MEMORANDUM

DATE: February 7, 2022  
*(Galloway Response to 2<sup>nd</sup> Round Comments – 03/31/2022)*

SUBJECT: CDR-21-018 – Bent Grass / Woodmen Frontage Road Turn Lane  
Second Submittal

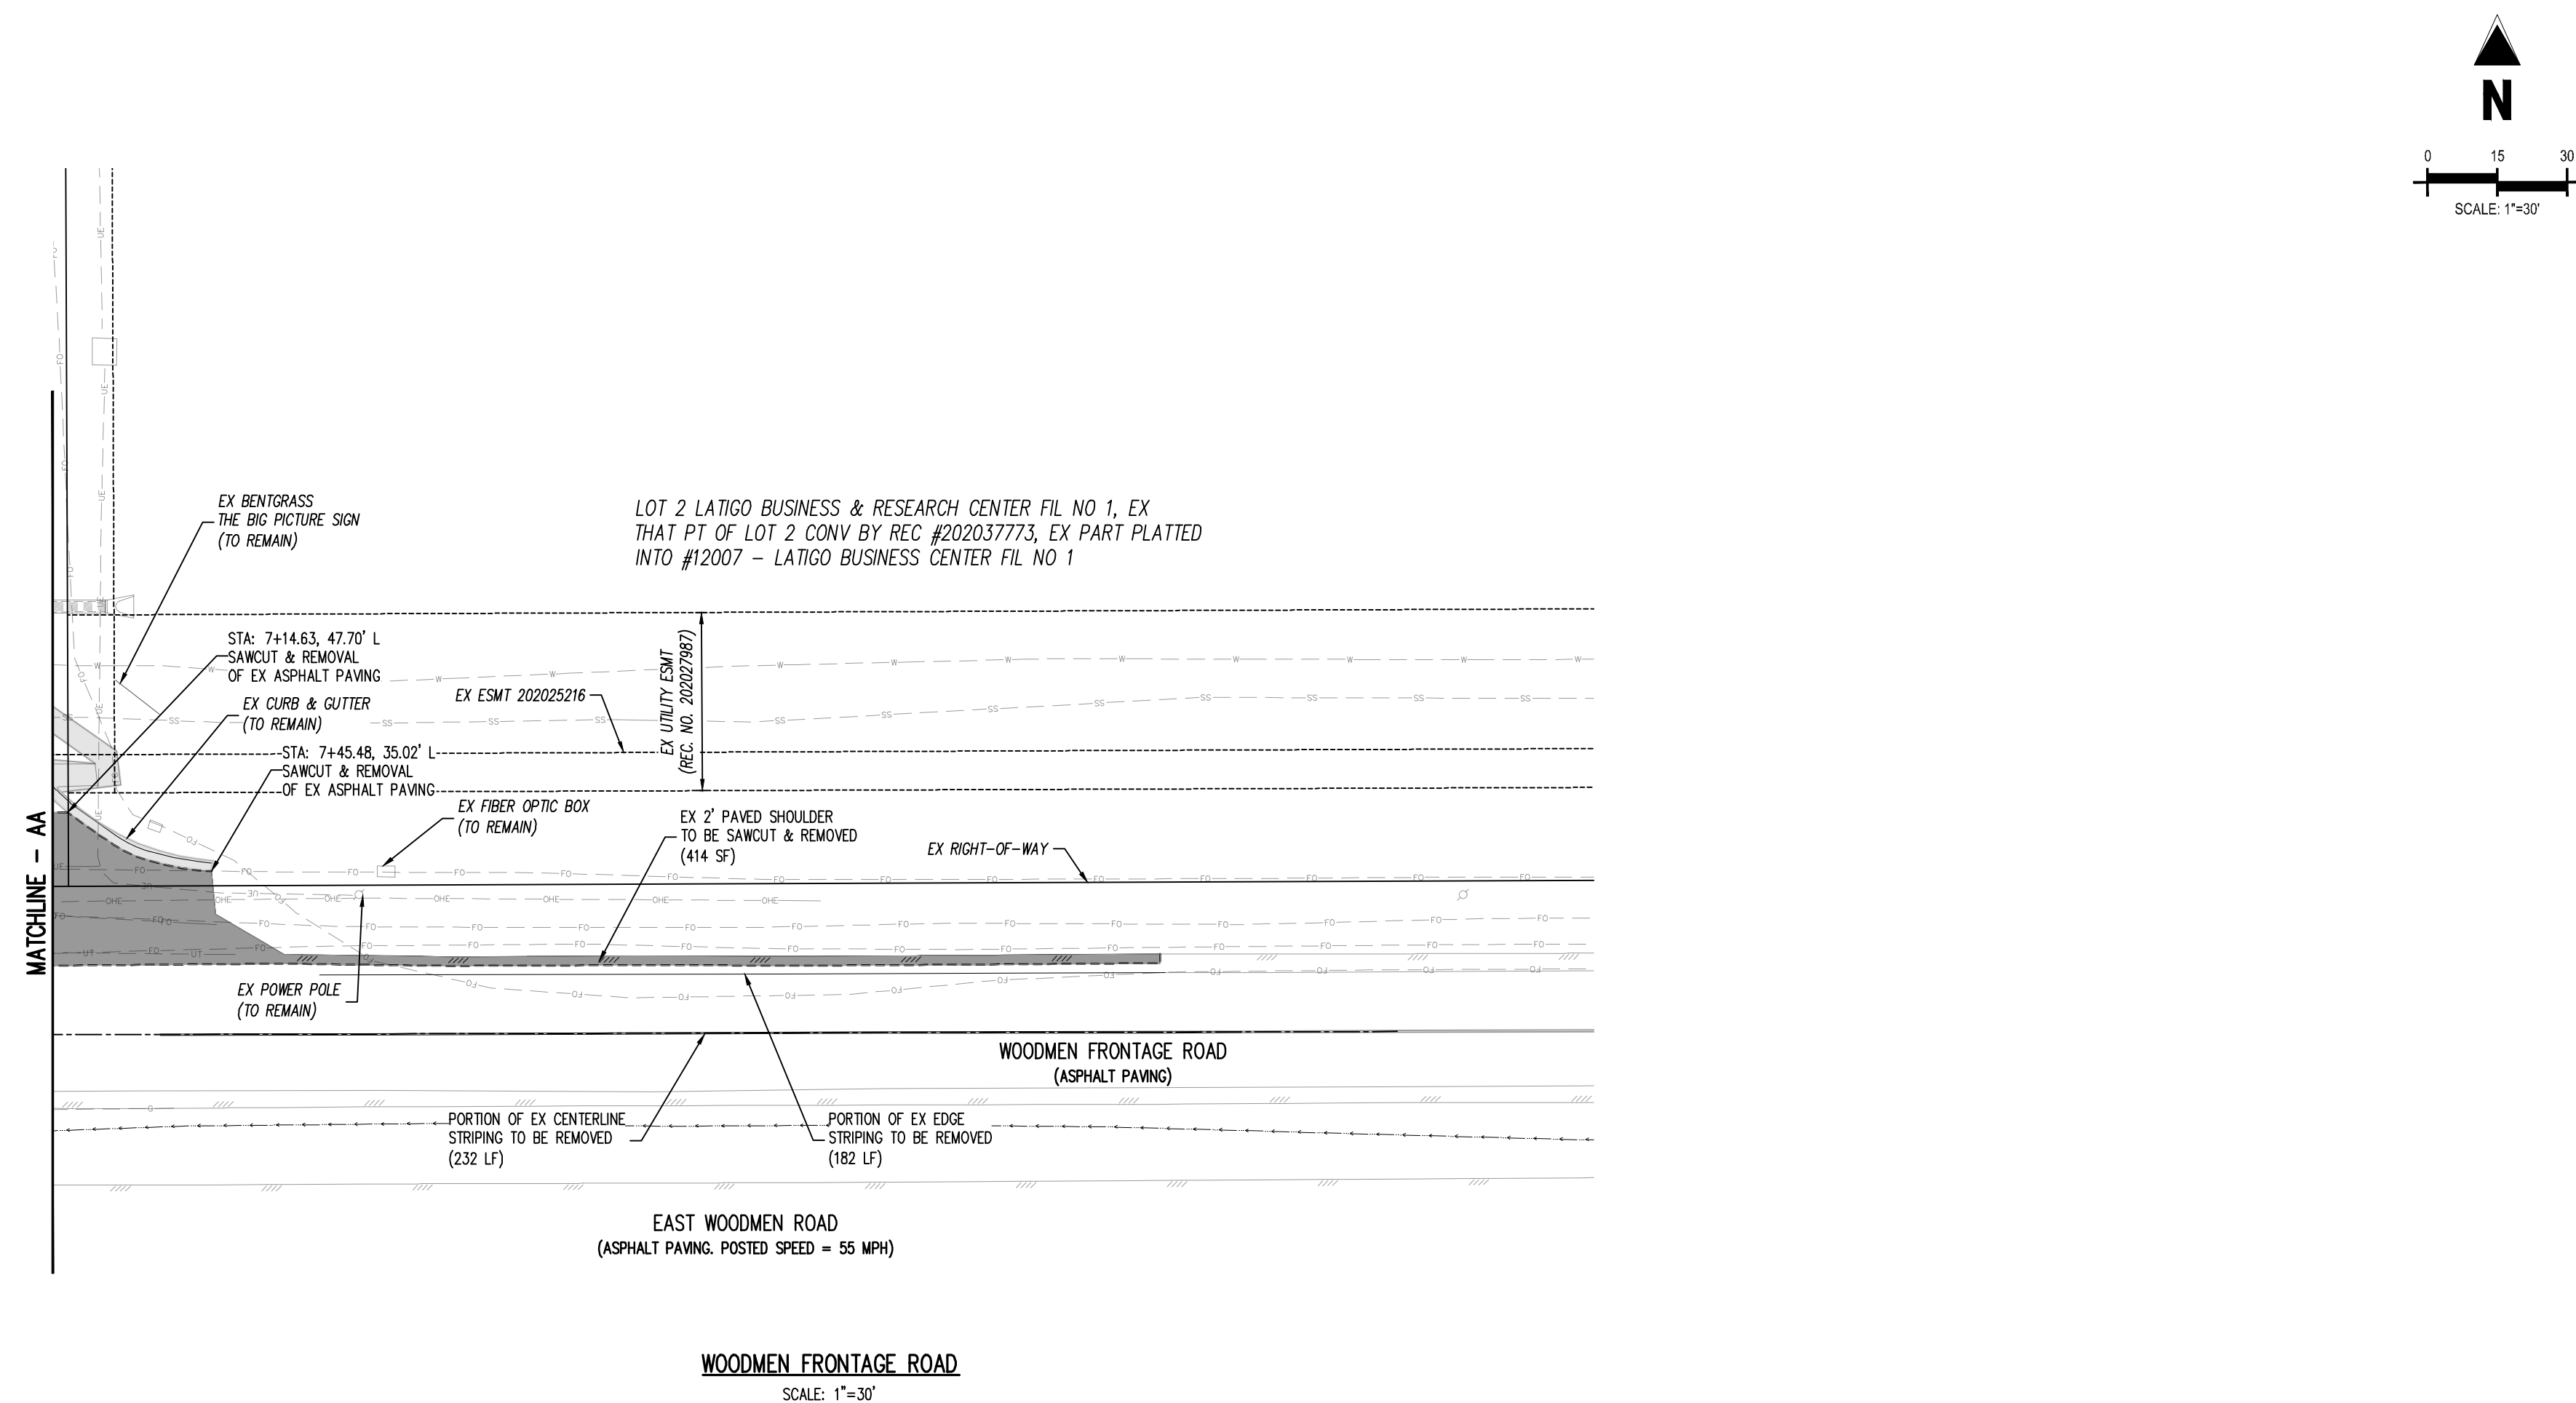
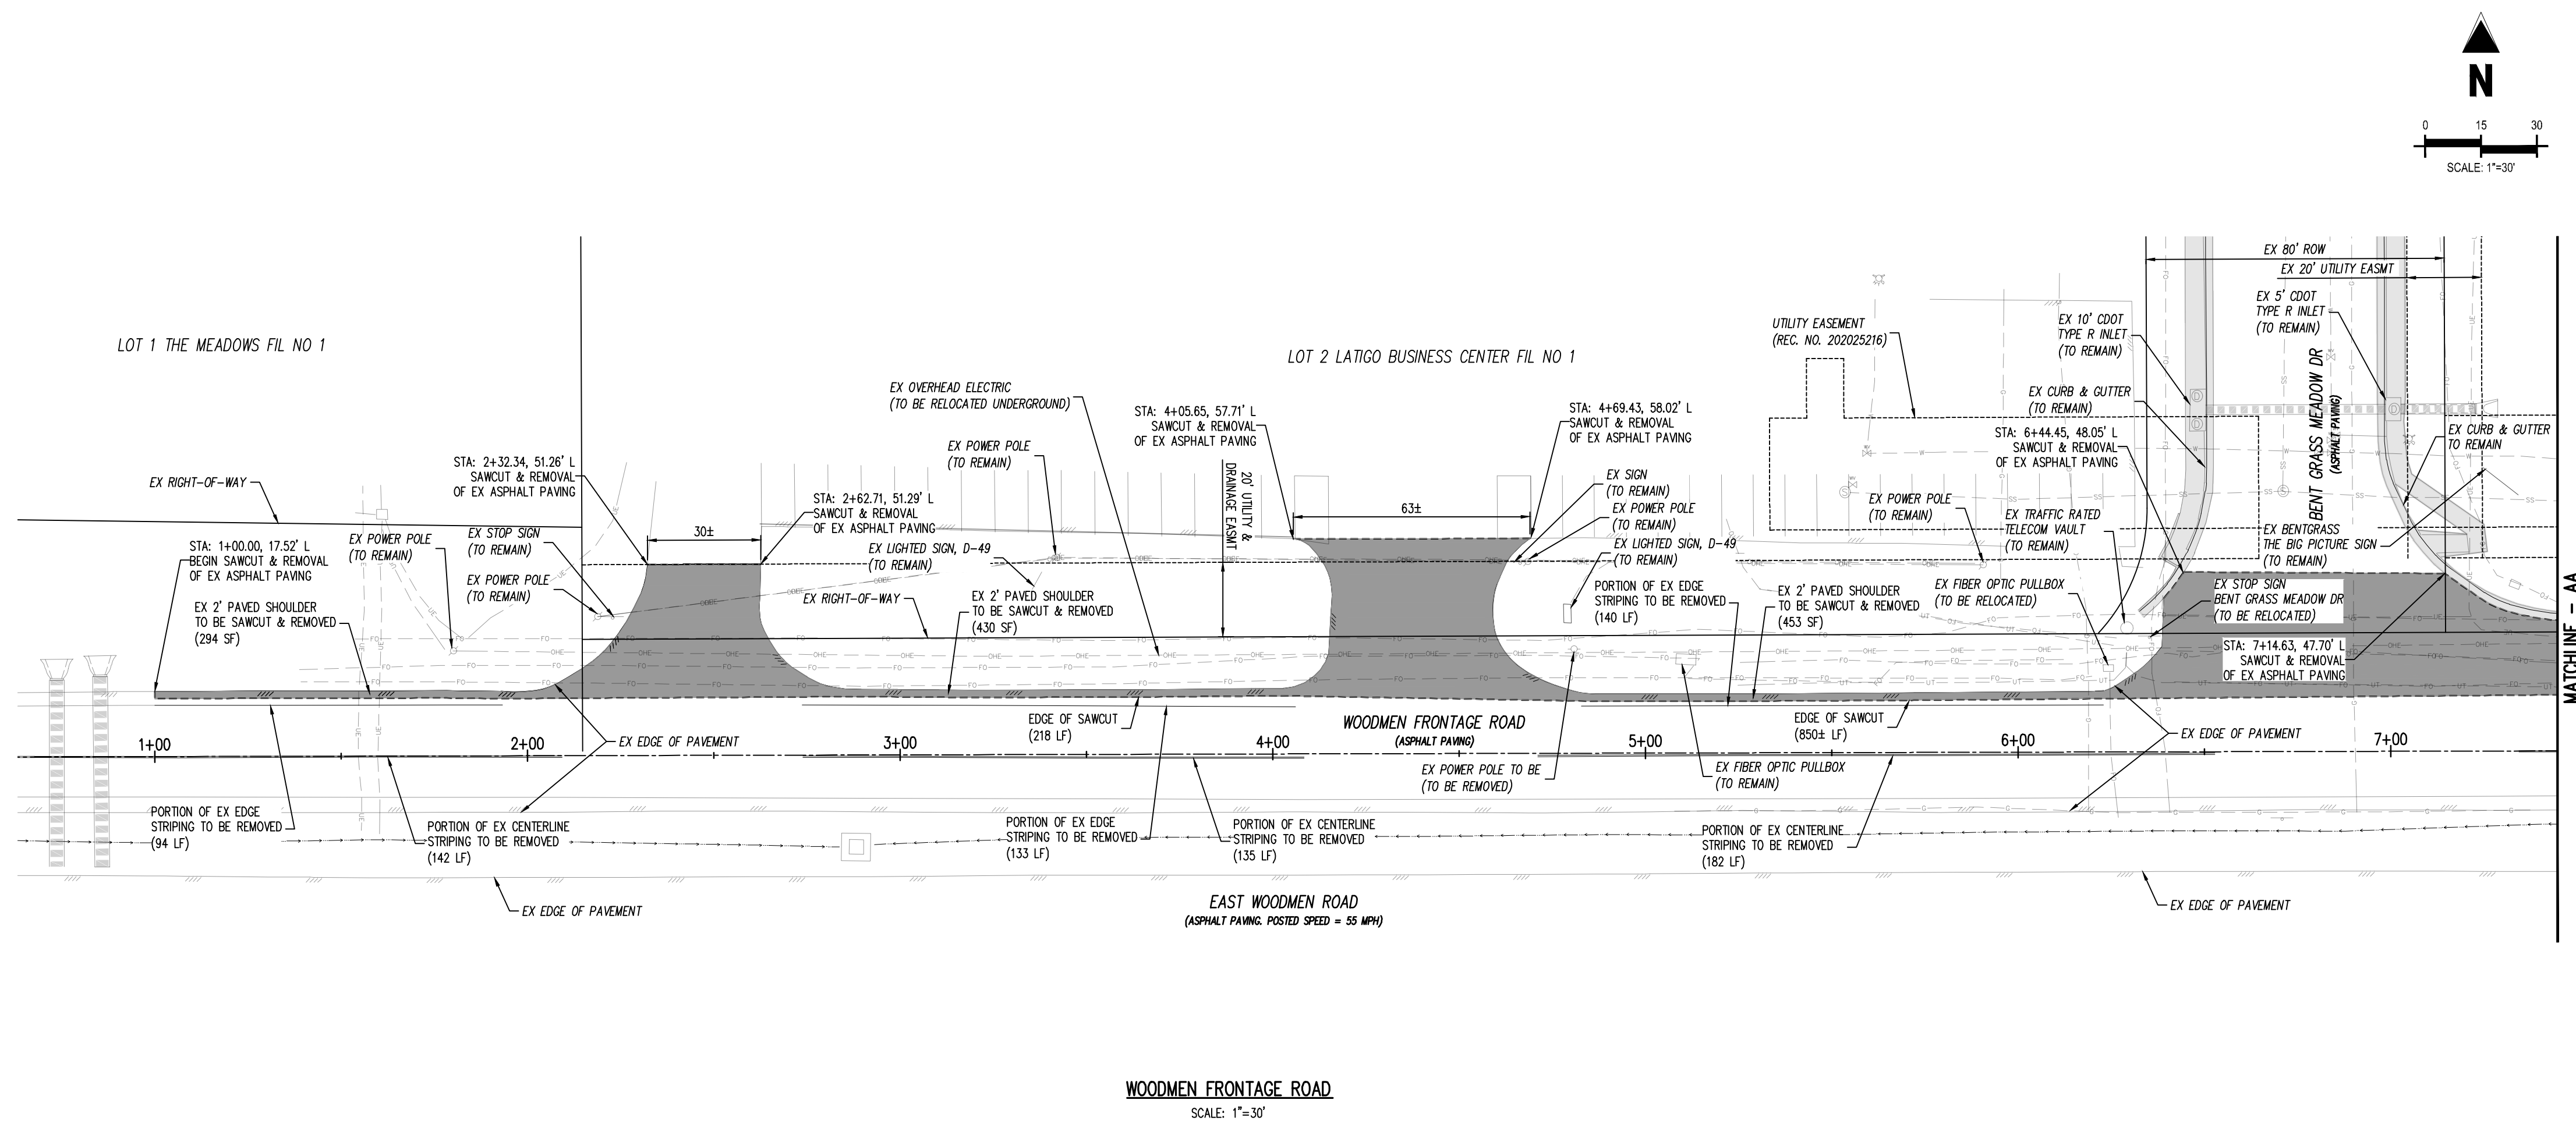
1. Note: As mentioned above, guardrail criteria need to be met or deviations approved; revise the CDs as appropriate. See ECM Table 2-42, CDOT M-606-1 Sheet 1 Note #4, CDOT Roadside Design Guide, and AASHTO Roadside Design Guide. Per the CDOT RDG, the following options need to be evaluated:  
Evaluation of the roadside environment entails six options:
  - Remove or redesign the obstacle so it can be safely traversed.
  - Relocate the obstacle to a point where it is less likely to be struck.
  - Reduce impact severity by using an appropriate break-away device.
  - Redirect the vehicle by shielding the obstacle with a longitudinal traffic barrier and/or crash cushion.
  - Delineate the obstacle if the above alternatives are not appropriate.
  - Make no change to existing. See the CDOT Project Development Manual (10), Section 2.09.

1. All property lines/ROW and easements need to be shown on all sheets and in the cross-sections.

2. For a major rural collector, shoulder widths need to be 4' paved and 4' gravel. It appears that this will push the shoulder past what looks like the property line. This will require additional ROW acquisition unless a public improvements easement will suffice for the County Engineer. Either way, it appears that additional ROW and easements will be required.

3. All existing utilities & structures need to be shown on all sheets. It appears that some utility boxes/structures will need to be relocated.

***Response: We are coordinating with El Paso County Staff on the guard rail and will make any required revisions to the plans based on these discussions.***

**Response: All property lines/ROW and easements are provided. Please specify what we are missing if this comment is not considered to be addressed.**

**Response: We are coordinating with El Paso County Staff on the guard rail & shoulder width and will make any required revisions to the plans based on these discussions.**

**Response: All utilities & structures are provided. Please specify what we are missing if this comment is not considered to be addressed.**
